October 5, 2016

Re: 1400 San Mateo Building
1400 San Mateo Blvd SE
Traffic Circulation Layout
Architect's Stamp 09-22-16 (L18D081)

A10 of 14

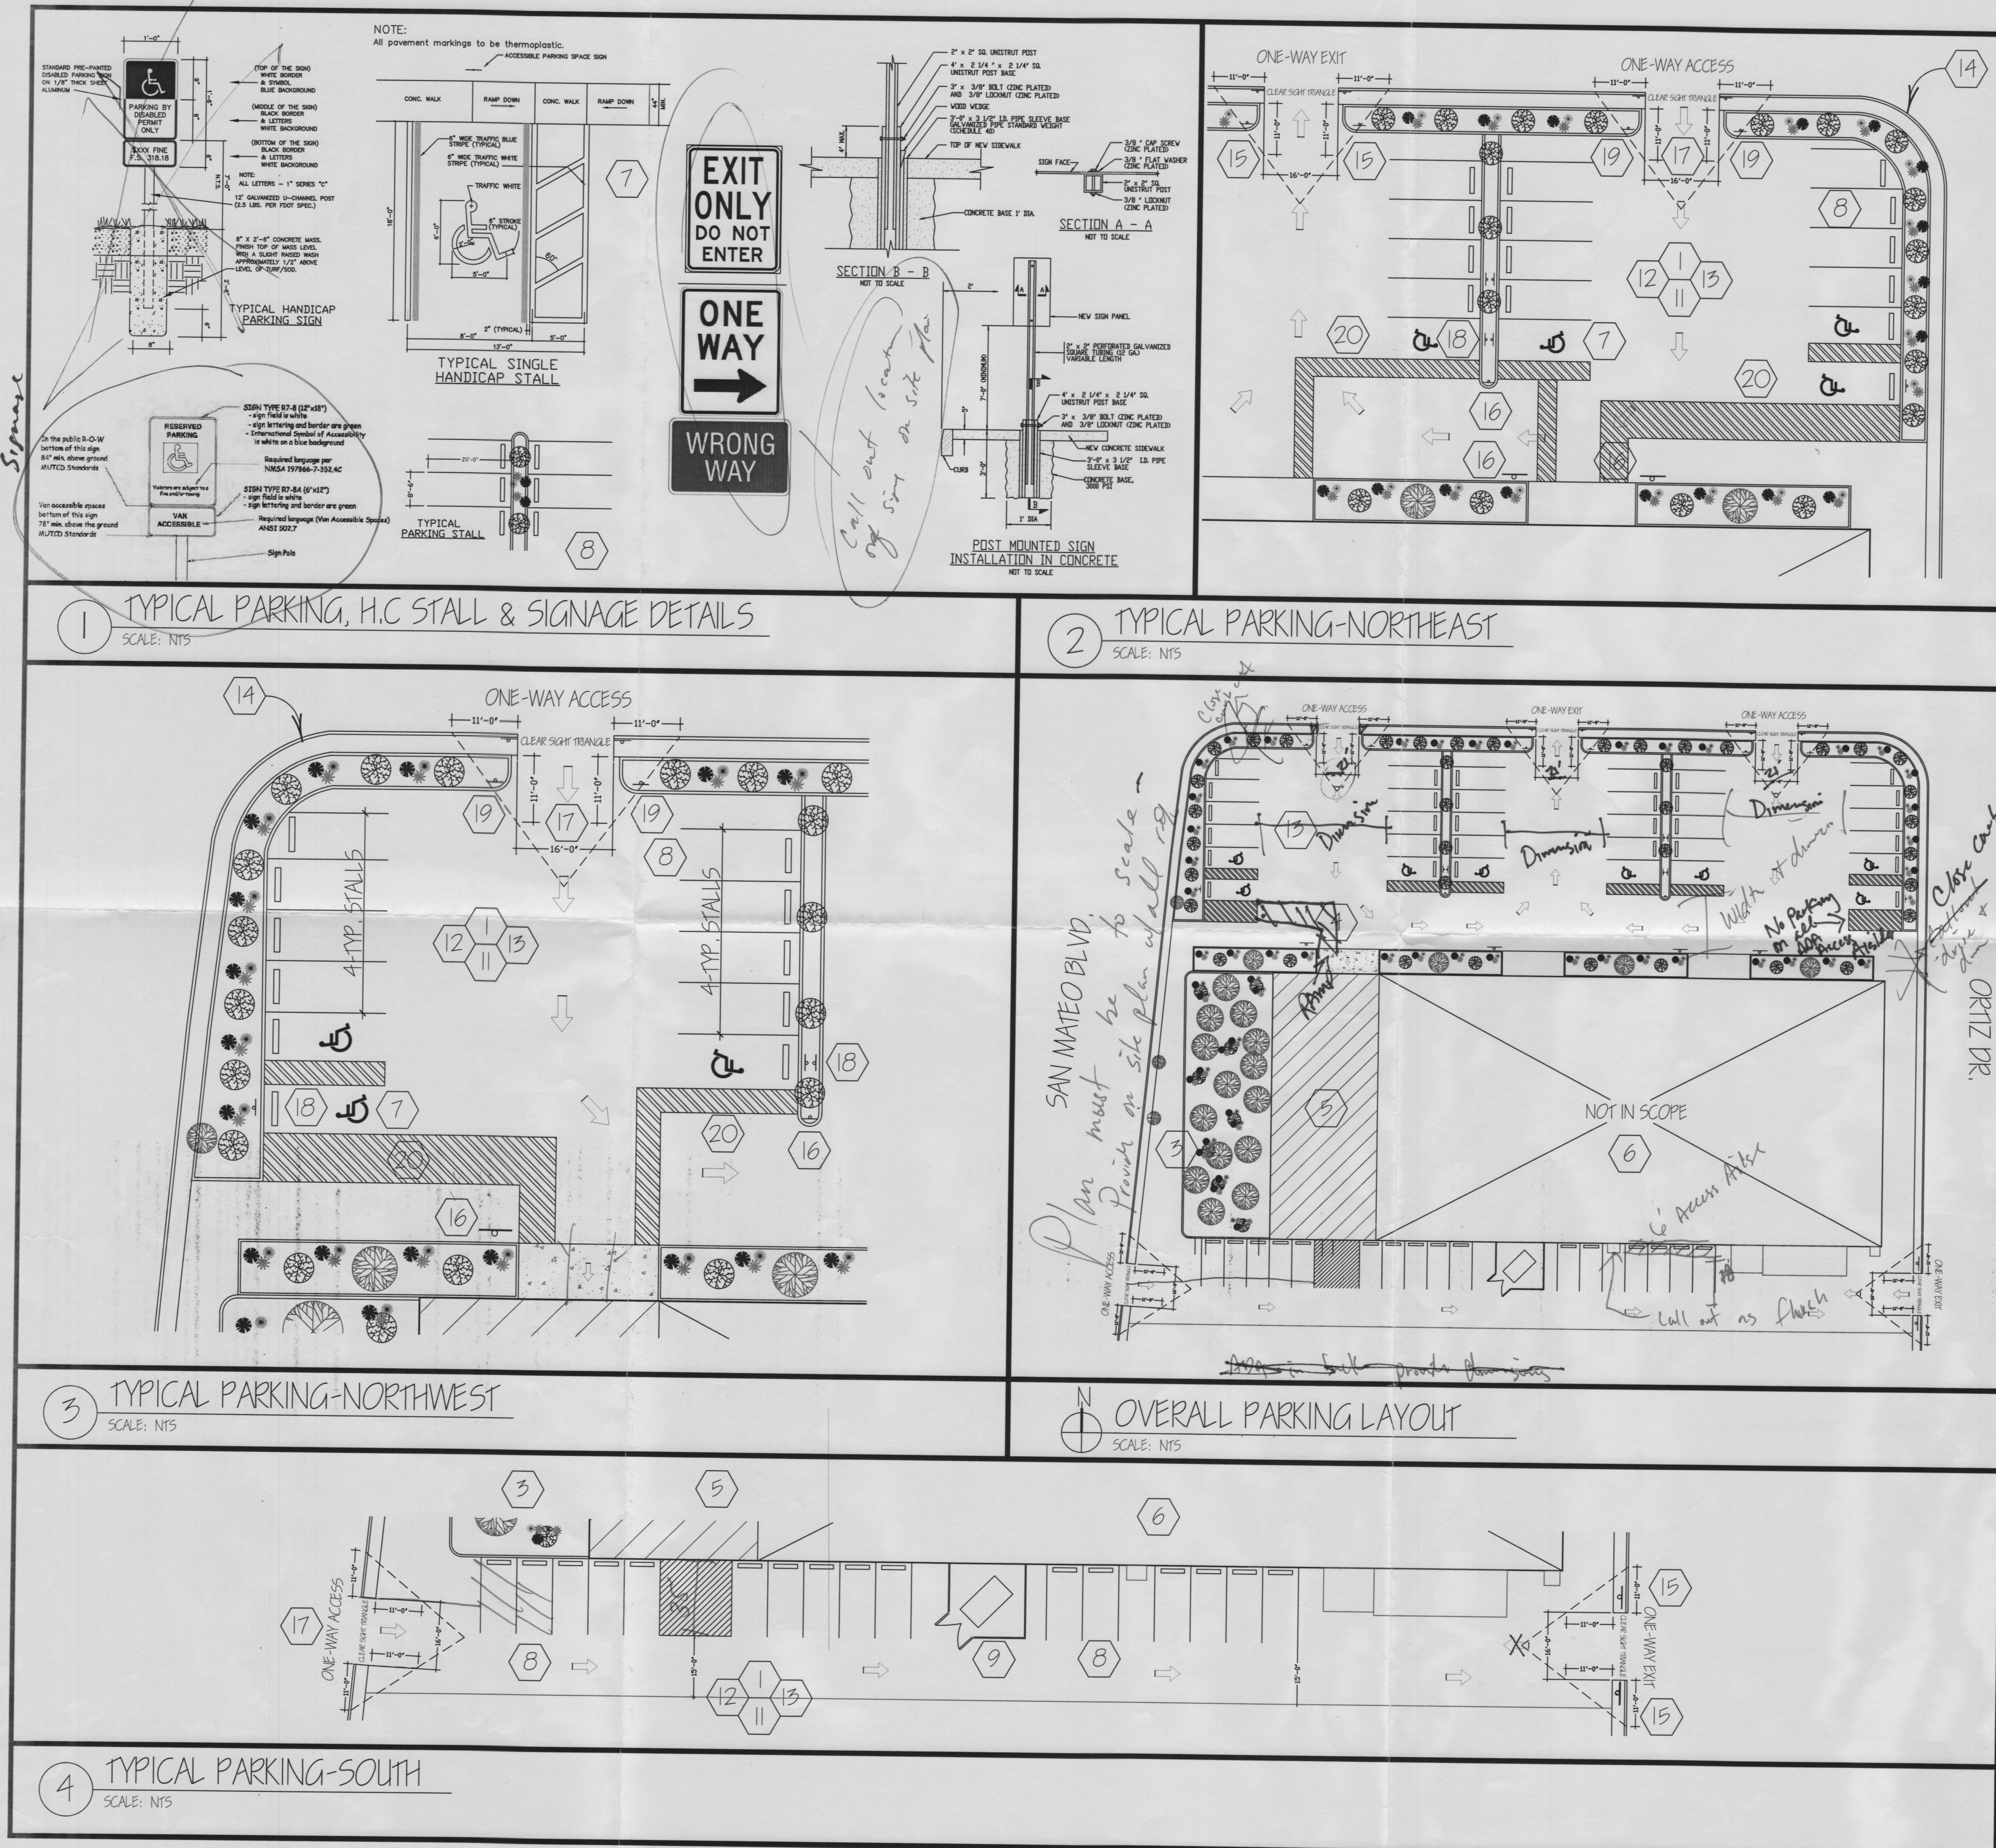
3. Per the zoning code, a 6 ft. wide ADA accessible pedestrian pathway is required from the public sidewalk to the building entrances. Please clearly show this pathway and provide details.

4. Minimum drive access drive aisle width must be a minimum of 24 feet for two way traffic. Any width less than 24 feet must be one-way access only.
5. One-way vehicular paths require pavement directional signage and a posted **"Do Not Enter"** sign at the point of egress. Please show detail and location of posted signs.

6. Call out all existing and proposed access drives. Please identify any existing access drives that will be modified. Unused curb cuts must be replaced with sidewalk and curb & gutter. A build note must be provided referring to the appropriate City Standard drawing.

7. See Chapter 23, Section 6 of the City of Albuquerque *Development Process Manual*, for appropriate drive pad widths.
8. Please provide a sight distance exhibit

9. Show the clear sight triangle and add the following note to the plan:
"Landscaping and signage will not interfere with clear sight requirements. Therefore, signs, walls, trees, and shrubbery between 3 and 8 feet tall (as measured from the gutter pan) will not be acceptable in the clear sight triangle.

11. Add a note stating "All broken or cracked sidewalk must be replaced with sidewalk and curb & gutter." A build note must be provided referring to the appropriate City Standard drawing.
12. Please include two copies and a PDF copy of the traffic circulation layout at the next submittal.
